From:
Sent: 18 May 2023 09:56
To: Kevin Walton
Cc:
Subject: Re Planning application 2023/62/90469/W
Attachments: annotated block plan.pdf

We have the following points to raise in respect of the above application.

Drawing Title  
**PLANS AND ELEVATIONS  
 AS PROPOSED.**

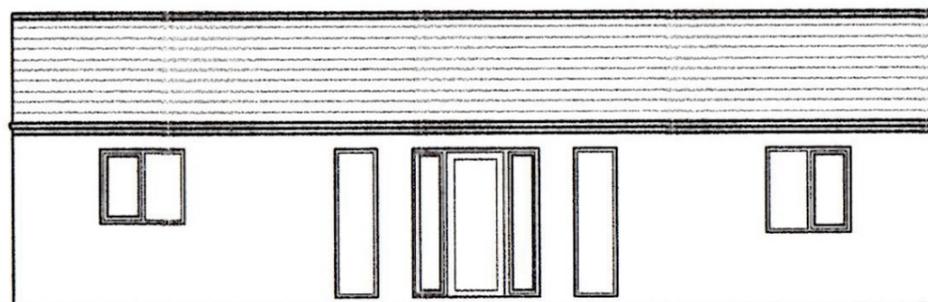
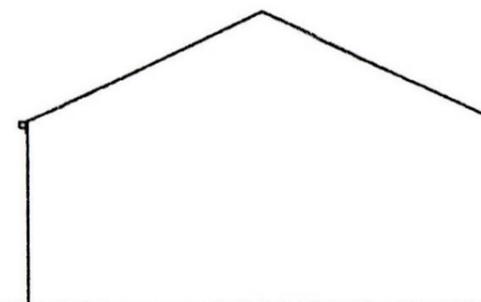
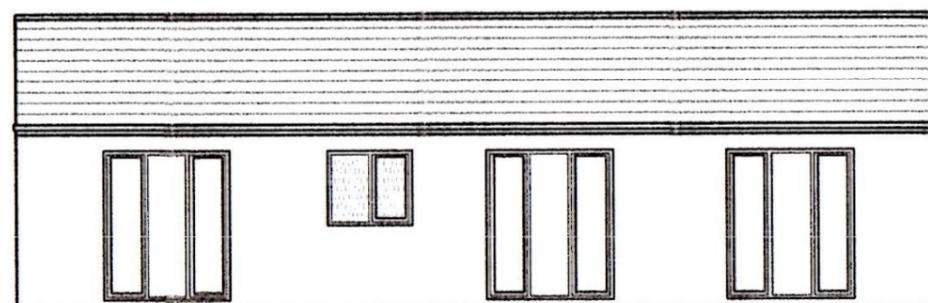
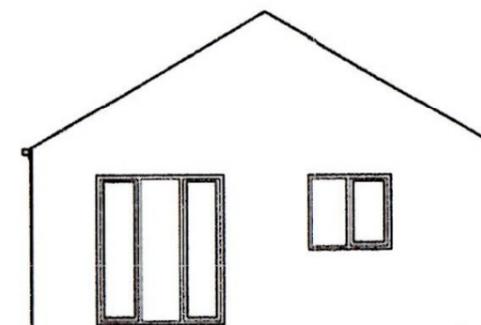
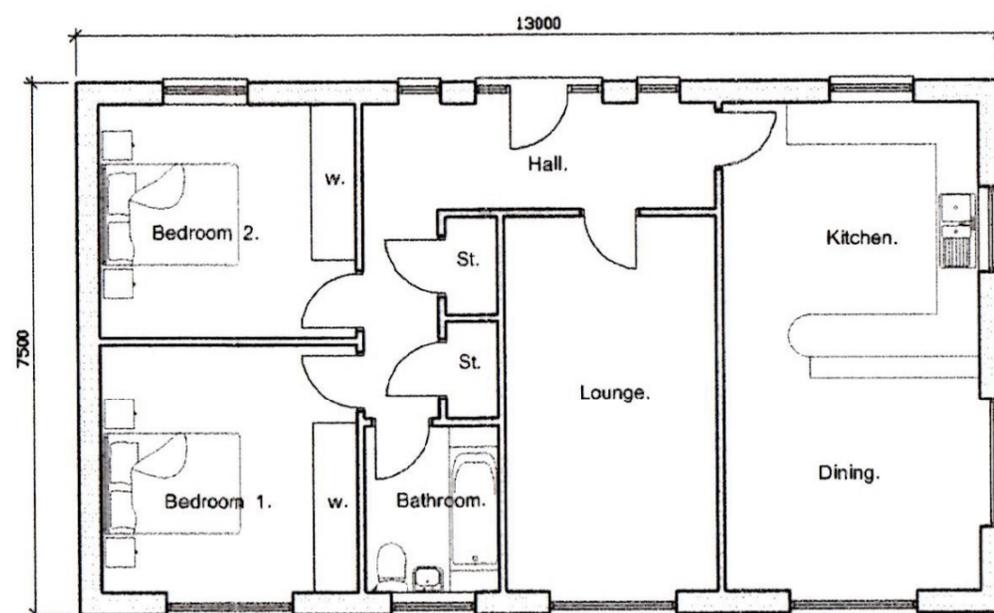
The location and size of the new building will inevitably have a visual impact on the landscape. The proposed plans do not state the height of the proposed building, so it is difficult to make an accurate assessment of the scale of this impact. The footprint of the building and overall size will be larger and more visually impactful than what is there currently.

In terms of the proposed new building. The windows will be on the elevation that directly overlooks

SCALE BLOCK PLAN

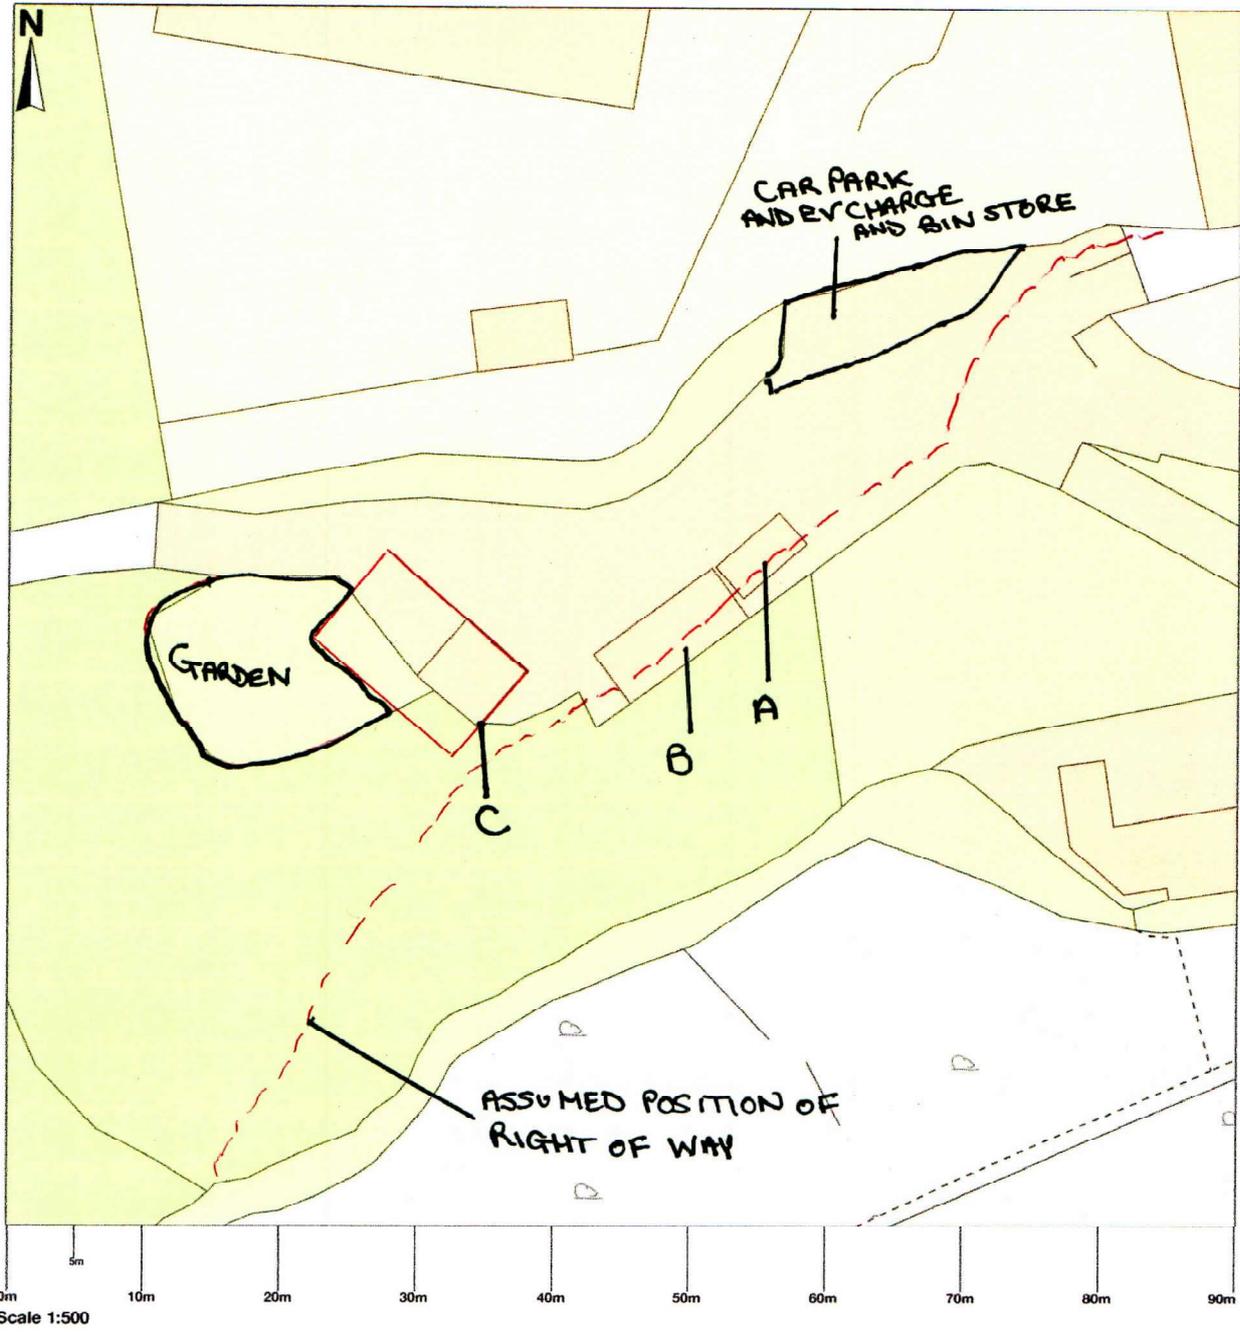
The block plan in the plans provided does not show the boundary between

This annotated block plan now demonstrates the proximity between the proposed parking area/ waste collection collection . Our concern is that the location of the parking and refuse collection . The proposal for a 2-bed unit, could result in an additional 2/3 cars parked several times a week, with associated activity of loading and unloading vehicles. It will inevitably create a noise impact, which will be heard both inside and outside of the property.
